From: Chris Wentworth
Sent: 24 May 2023 10:31
To: DC Support
Subject: FW: 23/00667/REM - OS Parcel 6372 South East Of Milestone Farm, Broughton Road, Banbury

From: Tim Screen <Tim.Screen@Cherwell-DC.gov.uk>
Sent: Monday, May 15, 2023 5:20 PM
To: Chris Wentworth <Chris.Wentworth@cherwell-dc.gov.uk>
Subject: 23/00667/REM - OS Parcel 6372 South East Of Milestone Farm, Broughton Road, Banbury

Apologies for the delay in responding. Please see my comments in respect of the above planning application.

Project details including scheme name (Balmoral Avenue Phase 2), client (Orbit Homes), drawing title (Landscape Proposals), date (February 2023), scale (1:200@A1), drawing number (ORB24157-11A Sheet 1 of 4), and drafter (TC) checker (SR).

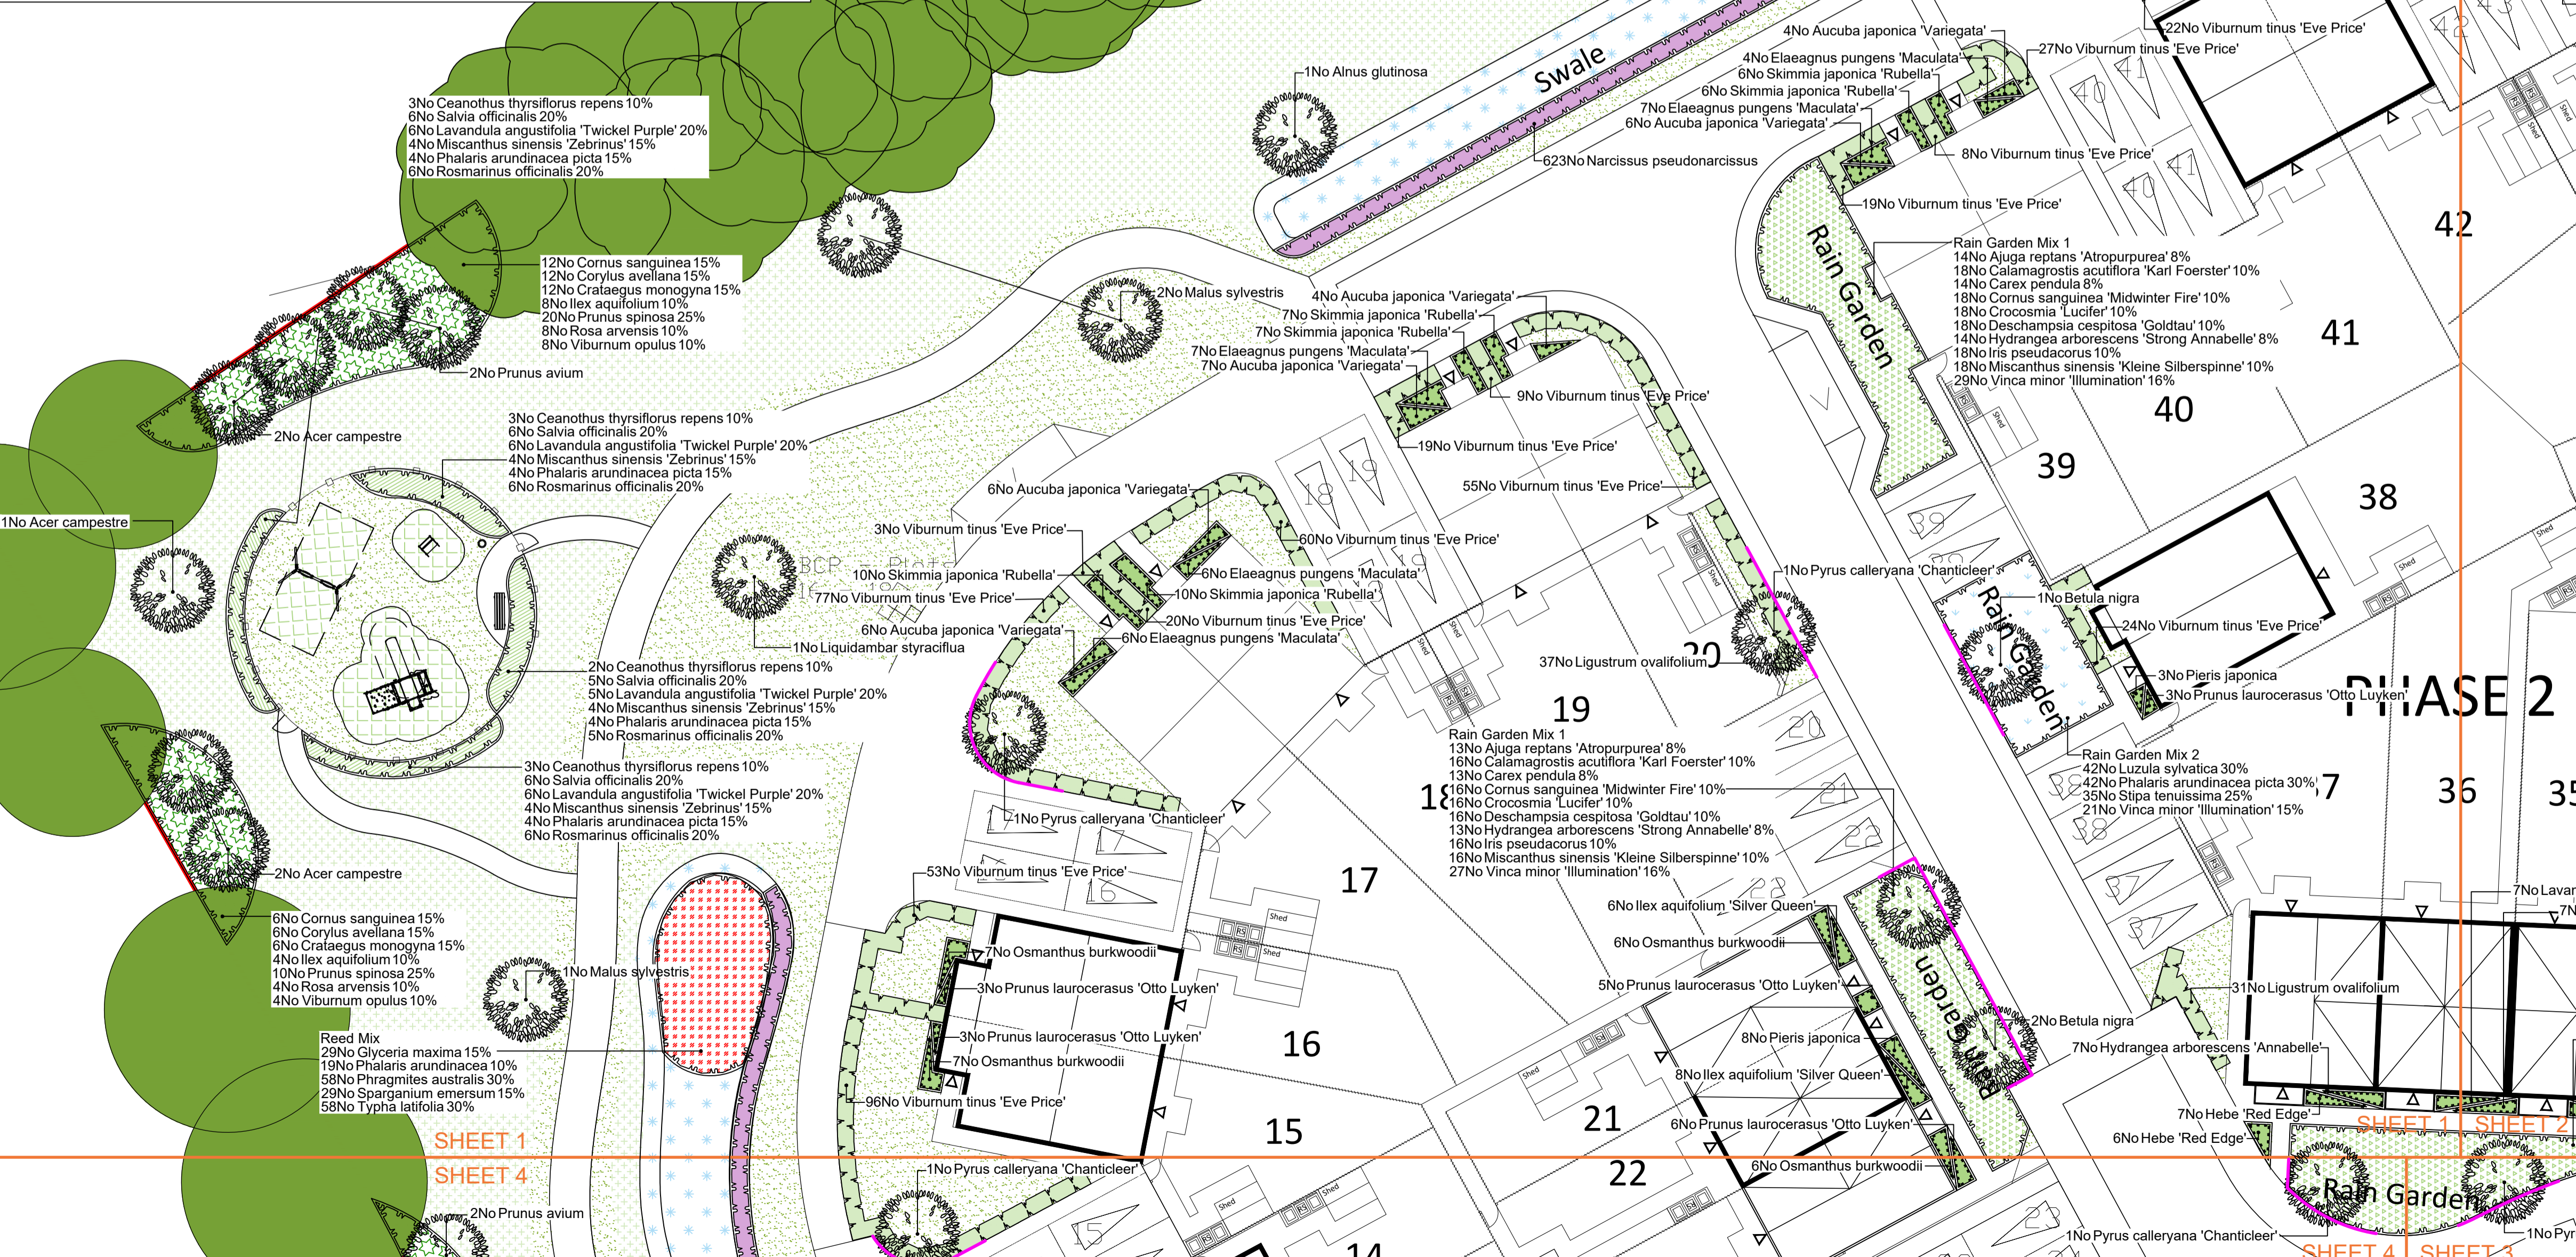
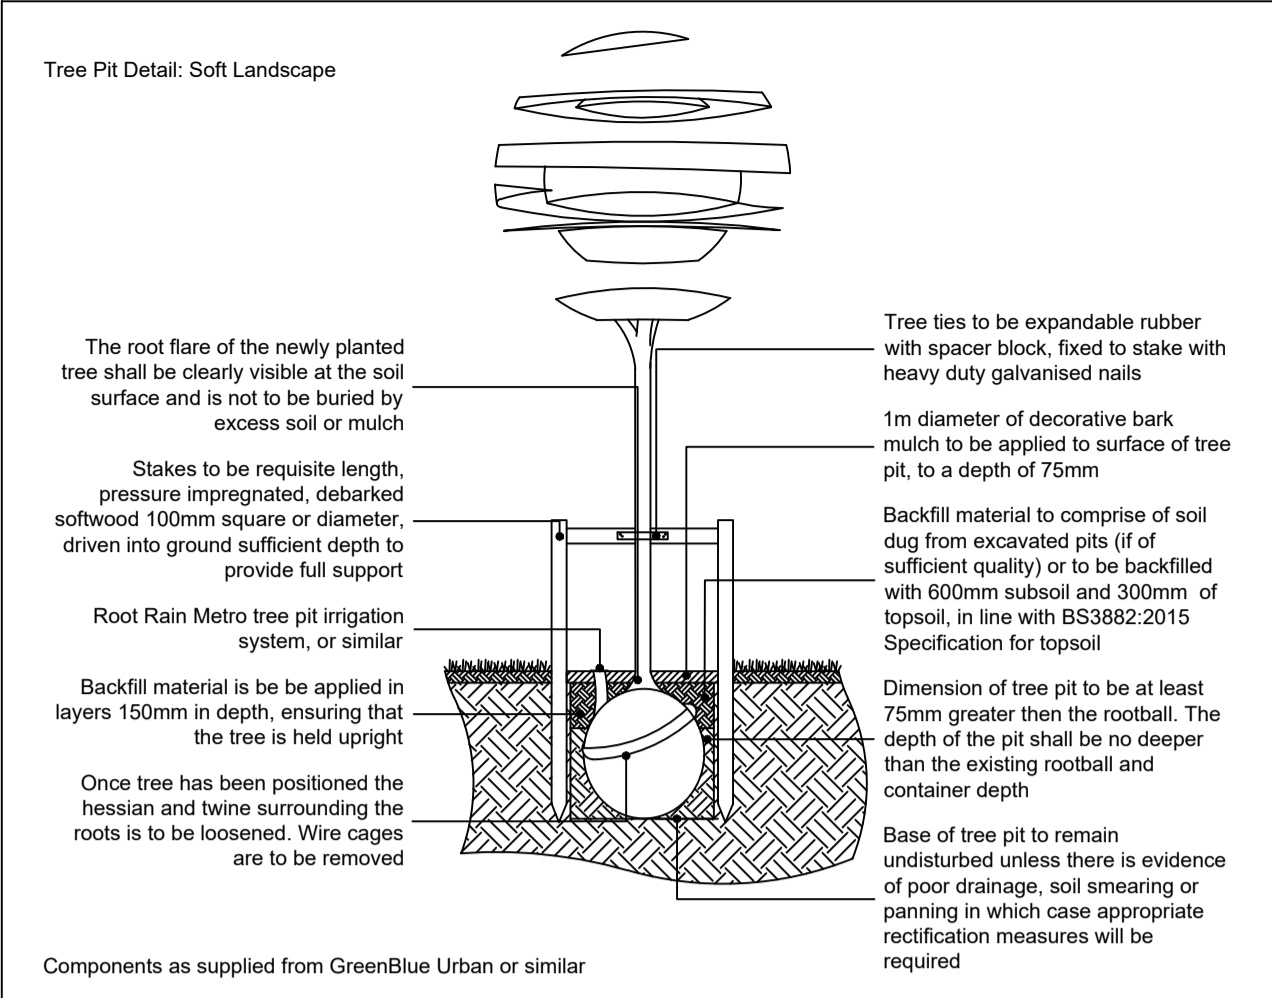
Replace *Betula pendula* south east of play area with 21 *Acer campestre*. Bp high levels of pollen with will exacerbate children's allergies.

Delete the two potentially large hornbeams (*Carpinus betulus*) from the rain garden/frontage of plot 31. The eventually large trees will be out of scale, will reduce light levels to SW facing rooms and front garden. Replace with one *Betula nigra*.

In order to improve the biodiversity net gain in the semi-natural areas replace the non-native *Alnus cordata* with the native *A. glutinosa* (by the swale. Replace the ornamental *Acer campestre* 'Streetwise' with the native field maple *A. campestre*

How deep is the water in the swale west of plots 15 and 16? I would recommend removing the proposed hedgerow from the periphery of this swale to ensure natural surveillance and in doing so improve the safety of children. Furthermore because the LAP is located on the periphery of the development the hedgerow will restrict natural surveillance of the LAP and encourage anti-social behaviour.

To improve the variety of movement experiences take away a springy animal, and replace with swing with a cradle for children with different levels of mobility age range 2 – 6 years. Redesign the play area to accommodate the swing. In this respect relocate some of the planting to the outside of the fence to free up space for the swing. Ensure that as the 'shade' tree canopy grows it will not encroach over play equipment because bird mess and other detritus is a health risk to children (additional cleaning will be necessary). Please the native *Acer campestre*.

Replace Hebe White Gem because it may not be as frost hardy and would require winter protection in gardens. Replace with Sage (*Salvia officinalis*)
